Project No. 21101

**Re: PA22-024- Marysville 44th PRD – Technical Review 2
7315 / 7417 44th St NE – APN(s) 30053500303700 / 30053500303600**

This letter is provided as response to comments dated November 7 and November 8, 2022. Each item has been carefully reviewed and considered and the following is a summary of how each item was addressed.

NTS COLLECTOR ARTERIAL

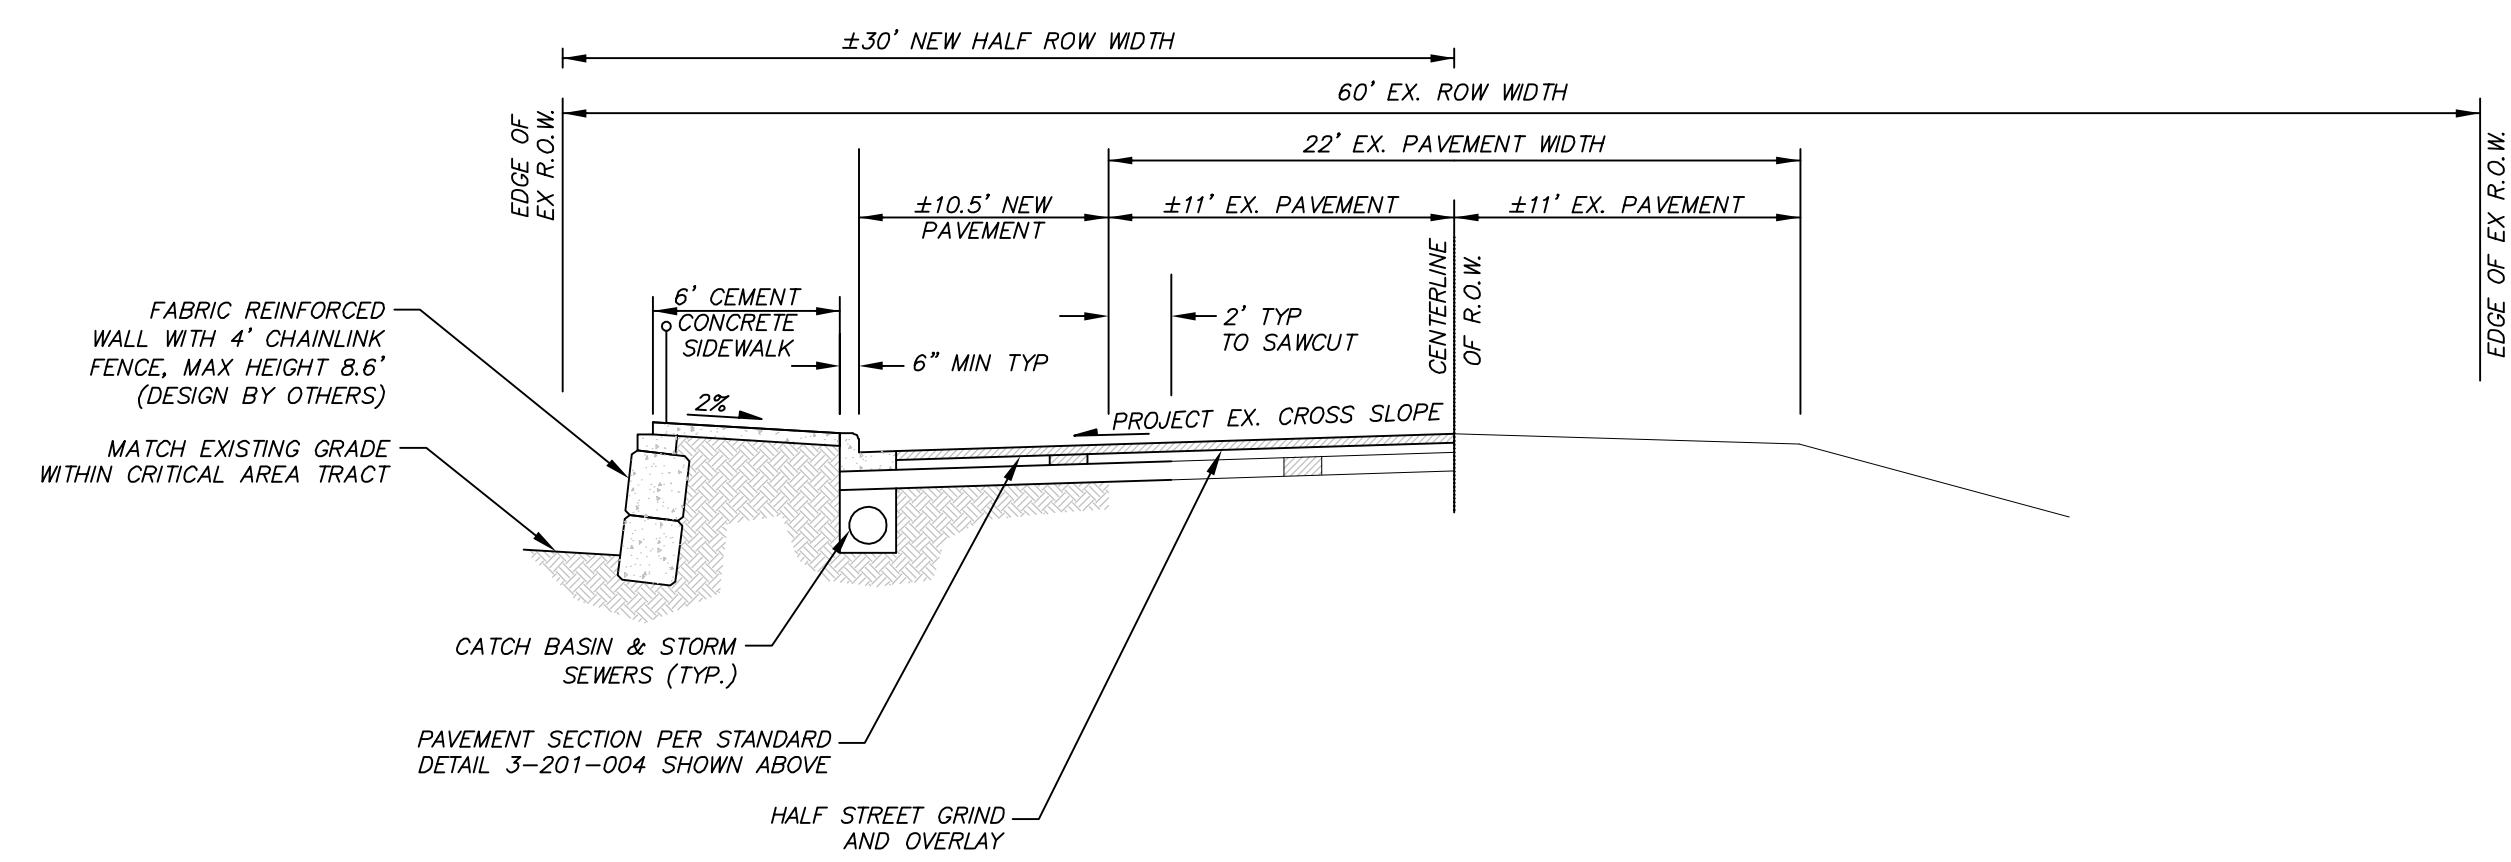
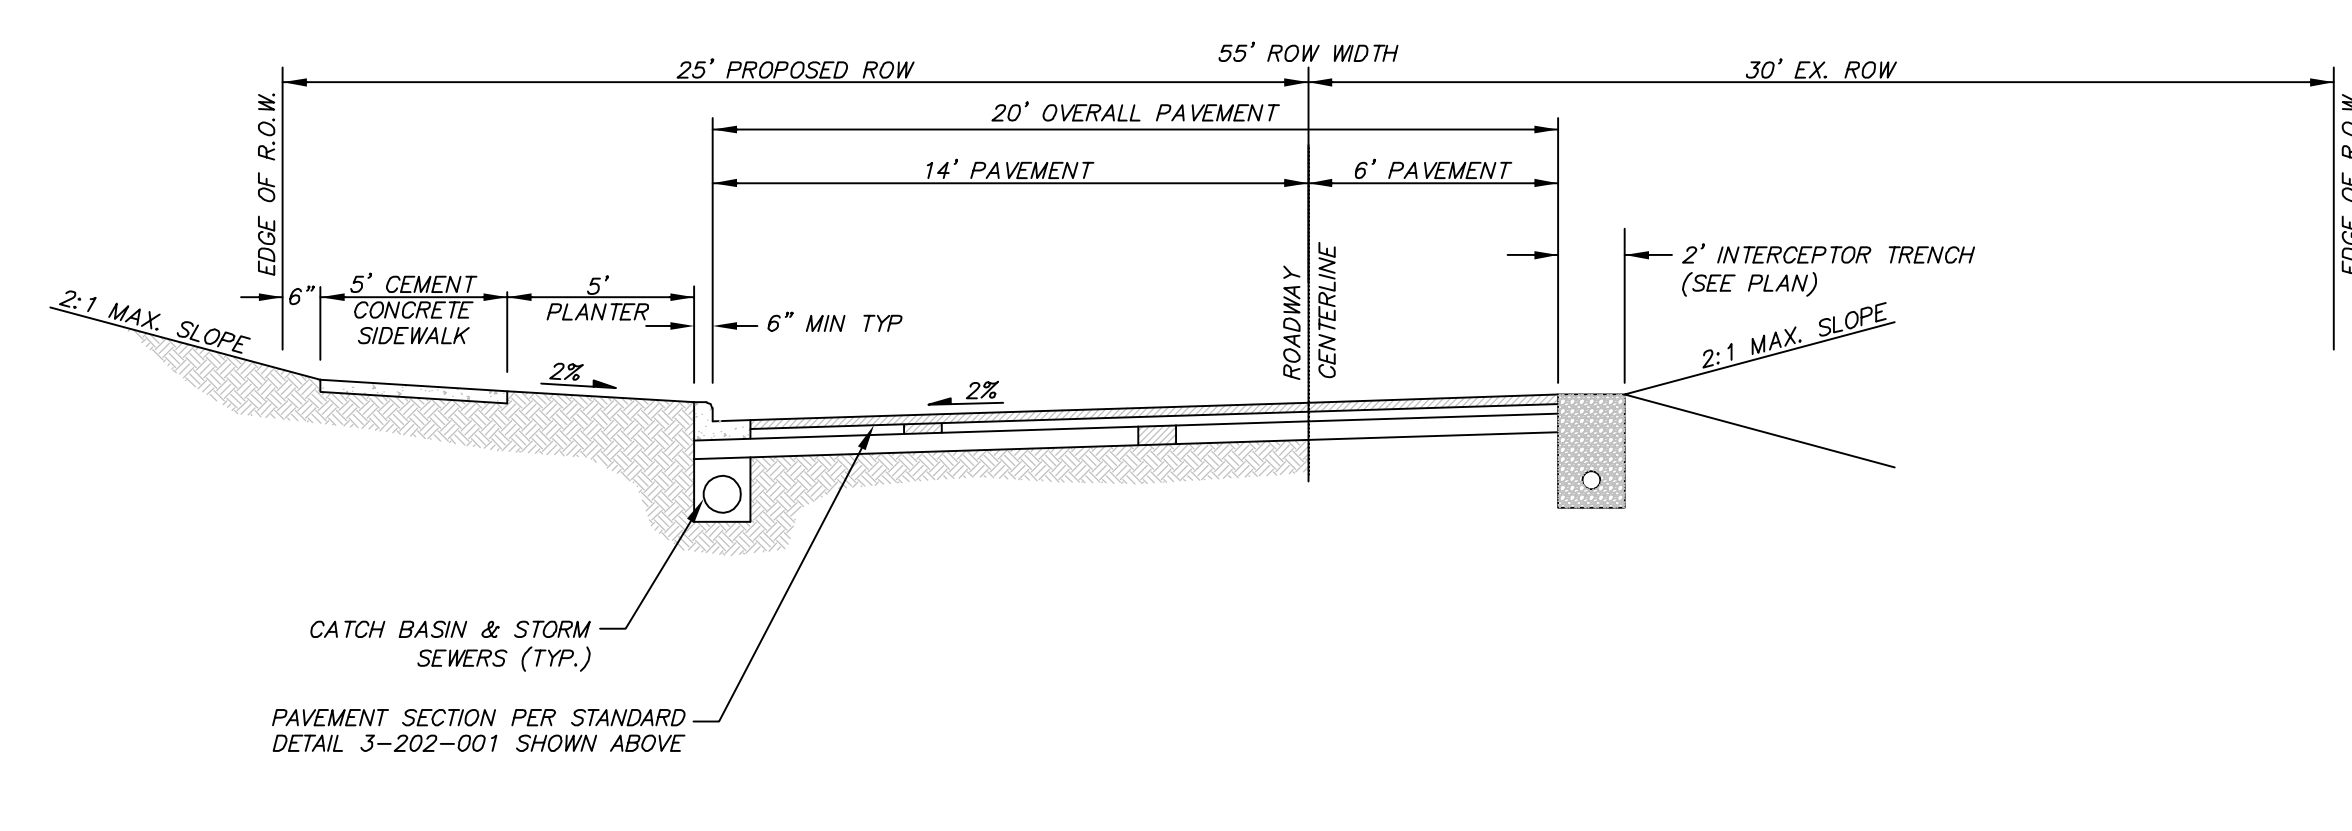
1. 44th ST NE:
 - a. Provide Stationing on 44th ST NE.
 - b. Site specific roadway cross-section *showing existing and proposed* components with dimensions within full ROW should be included upon plans.
Both are provided now.

2. 75th Ave NE:
 - a. Provide Stationing on 75th Ave NE.
 - b. Site specific roadway cross-section showing existing and proposed components with dimensions within full ROW should be included upon plans.
Both are provided now.
